KITTTITAS COUNTY COMMUNITY DEVELOPMENT SERVICES

RE: Kosar Variance Application (VA-23-00004) – Transmittal of Comments

Parcel # 902134

31 Eagle View Dr
Parcel 902134
7-10-23

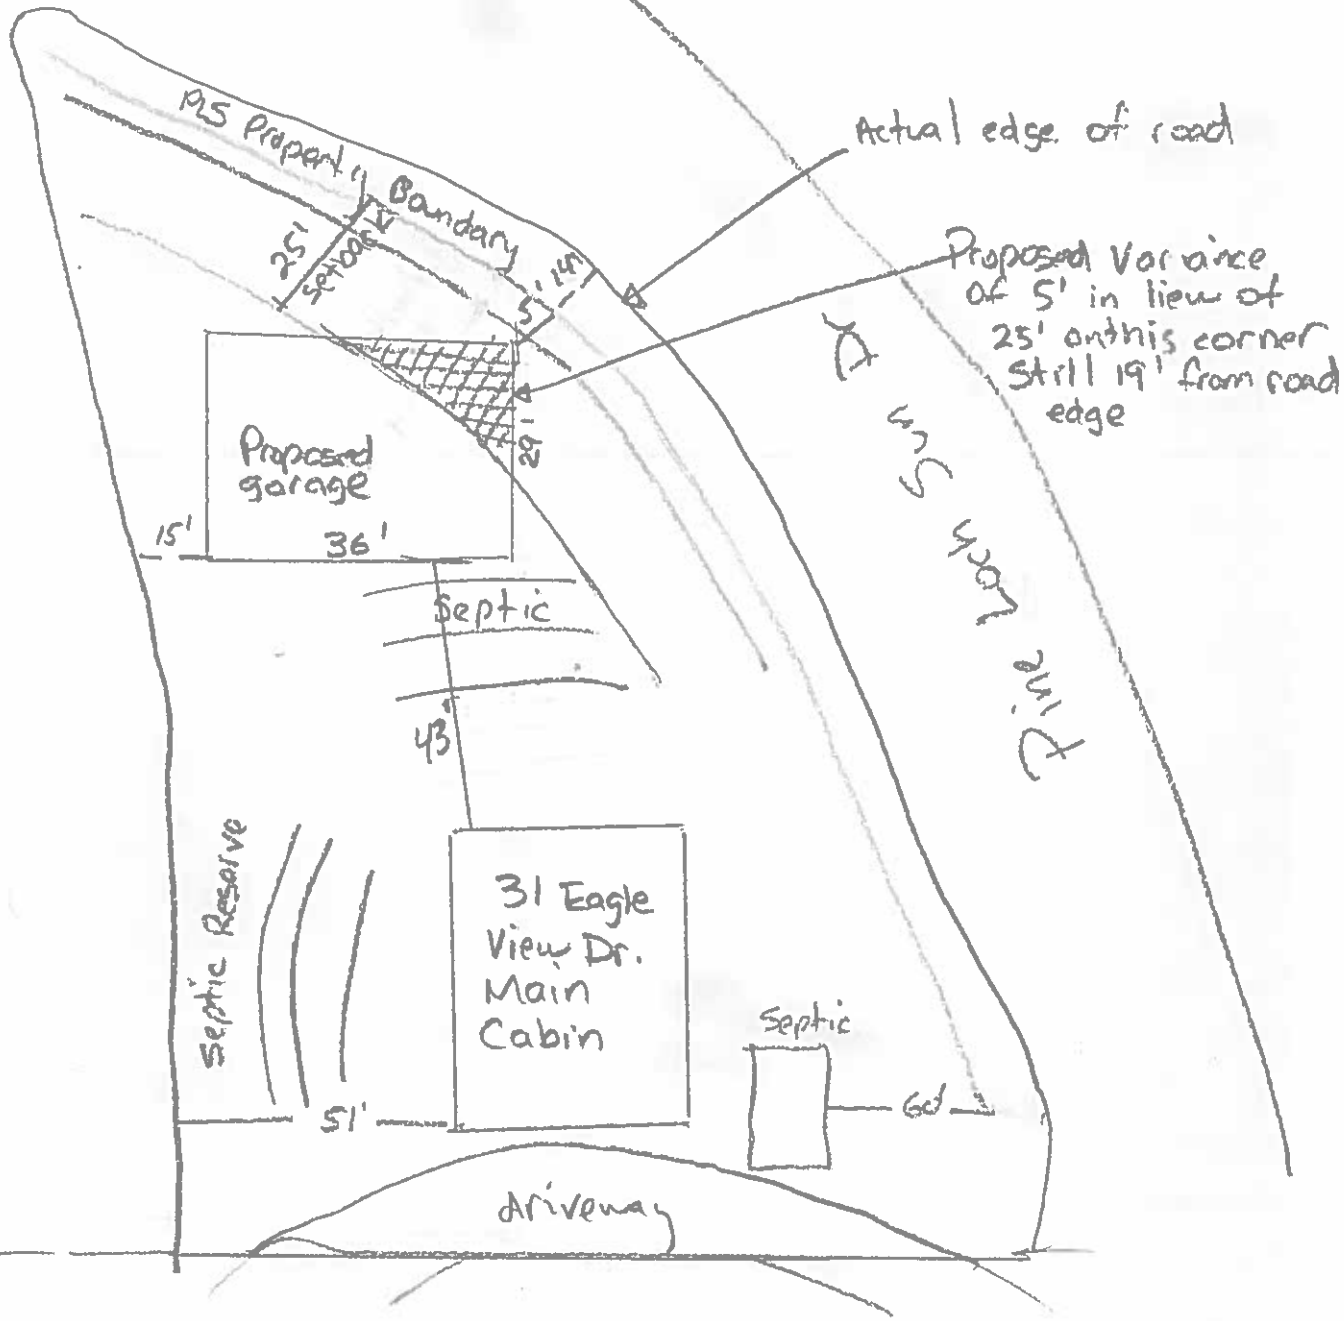
Staff is aware that you are working with Public Health on the septic reserve area issue. Please let community development services staff know of any updates on that matter as it progresses. If needing to move the proposed garage to a new location, please submit an updated site plan to our offices for review and noticing. Staff shall receive a new site plan or confirmation from Public Health that the reserve septic area has been adequately moved within 180 days (5p on Monday October 3, 2023) under KCC 15A.03.045. If not received by October 3, 2023, staff will process the variance as is and make a decision based on the information and comments already received unless a written extension is requested with a said date that this will be accomplished by pursuant to KCC 15A.03.045(2).
